LOT 1 OF THE ROCK COMMERCE CENTER SUBDIVISION FILING NO. 1

PUBLIC IMPROVEMENT PLAN CONSTRUCTION DOCUMENTS

LOT 1 OF THE ROCK COMMERCE CENTER SUBDIVISION FIL. NO. 1
PUBLIC IMPROVEMENTS PLAN
CONSTRUCTION DOCUMENTS
COVER SHEET

I:\2023\23009 - The Rock Commerce Center\CAD\Sheet Sets\CDs\PIP\23009_Signage & Striping Plan.dwg tab: Striping & Signage Oct. 20, 2023 - 2:34pm ccsz

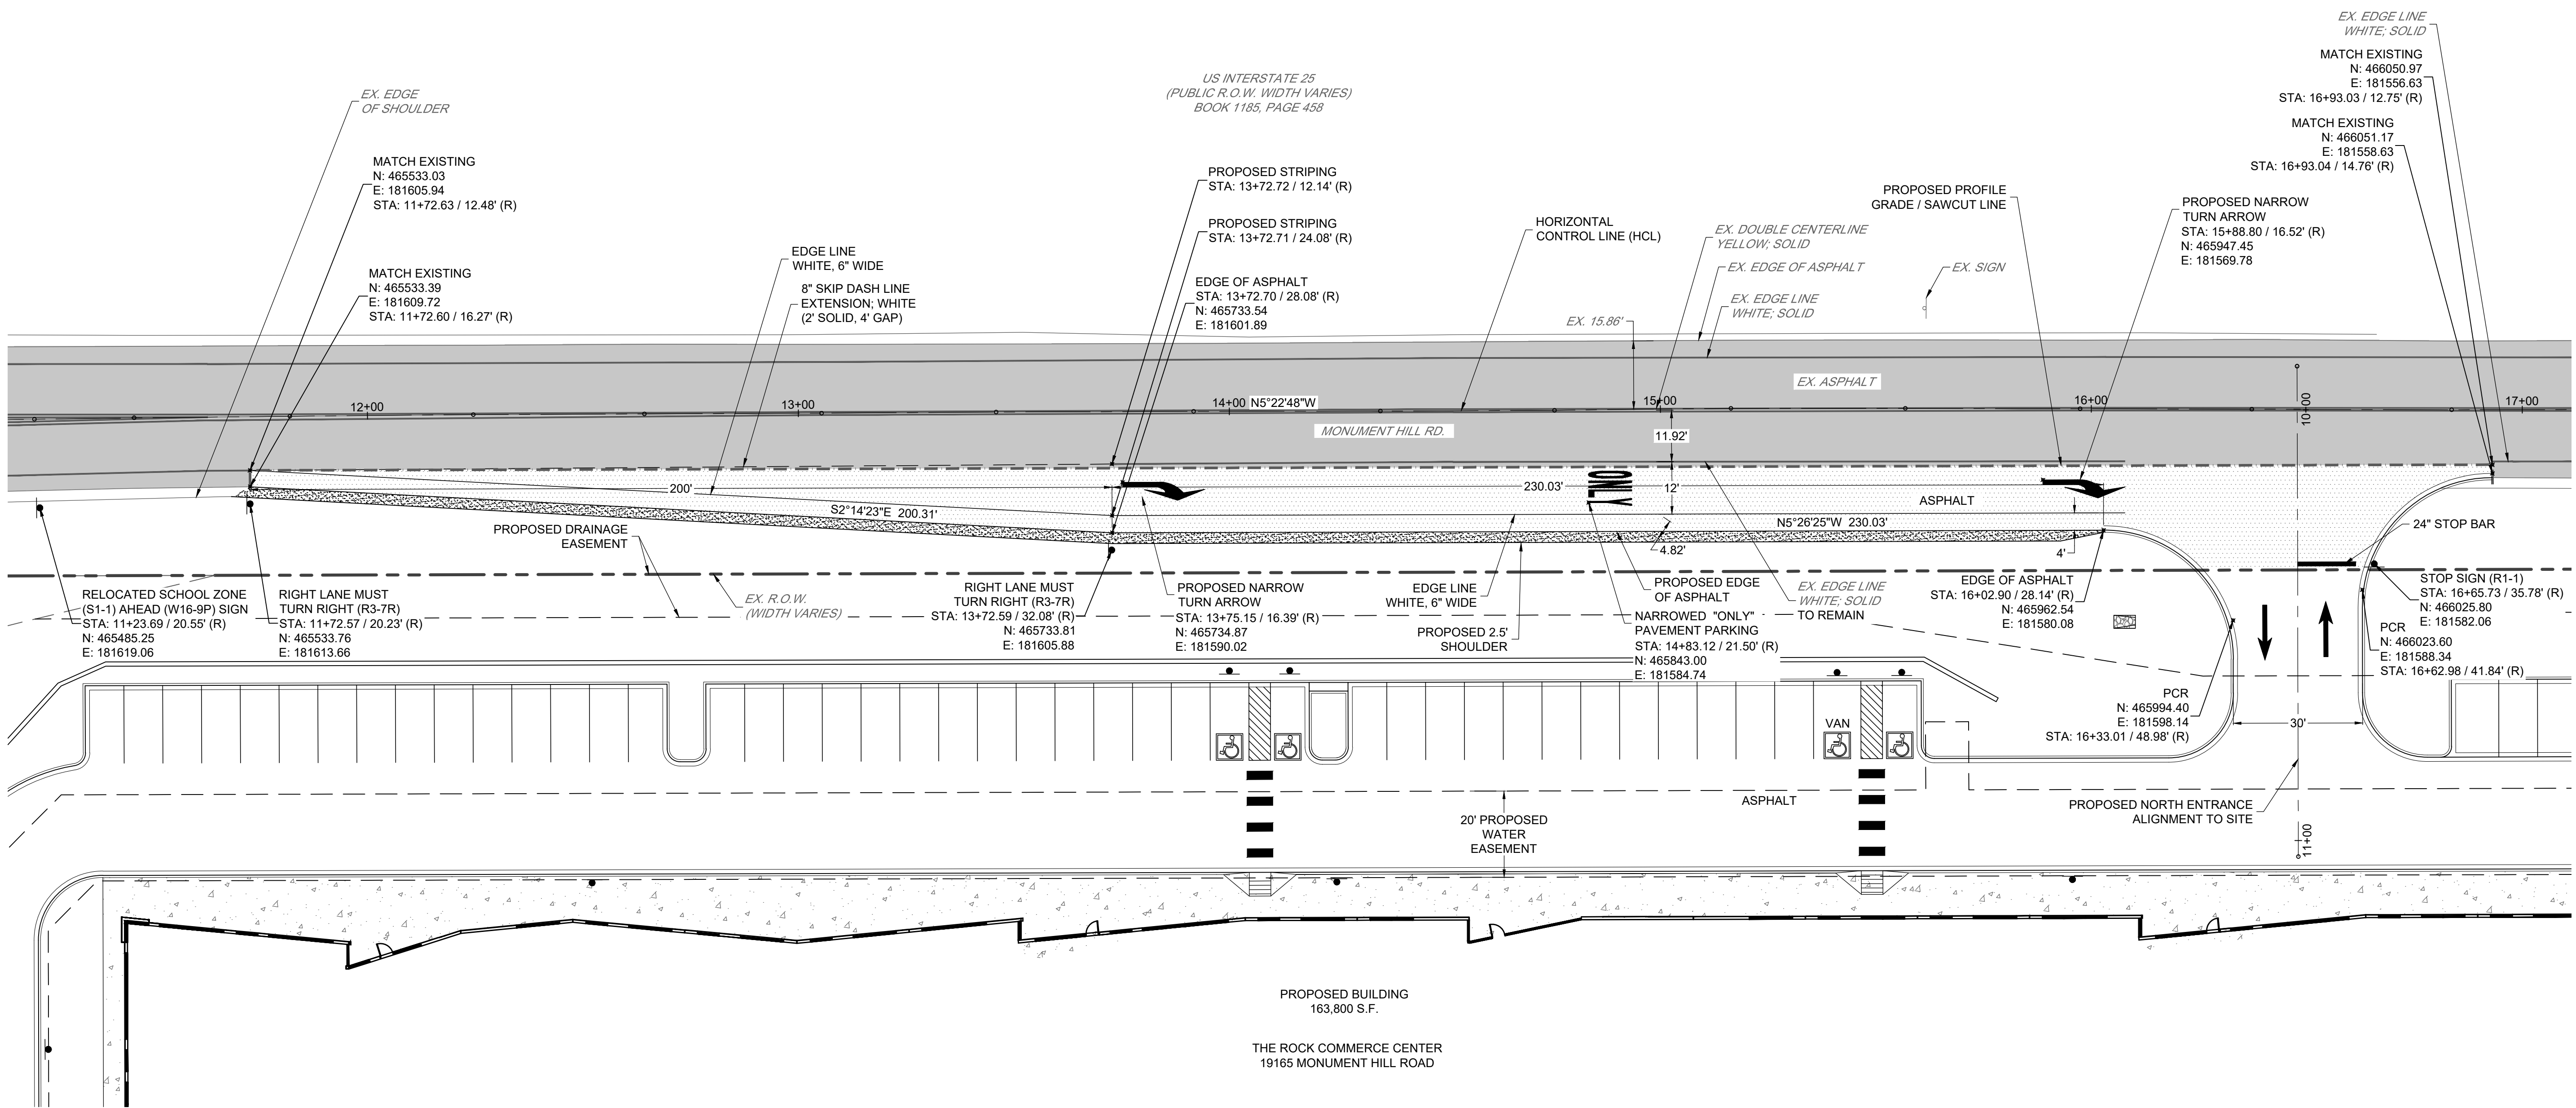
Per note 12 in standard signing and striping notes, all ward and symbols should be of the narrow type.
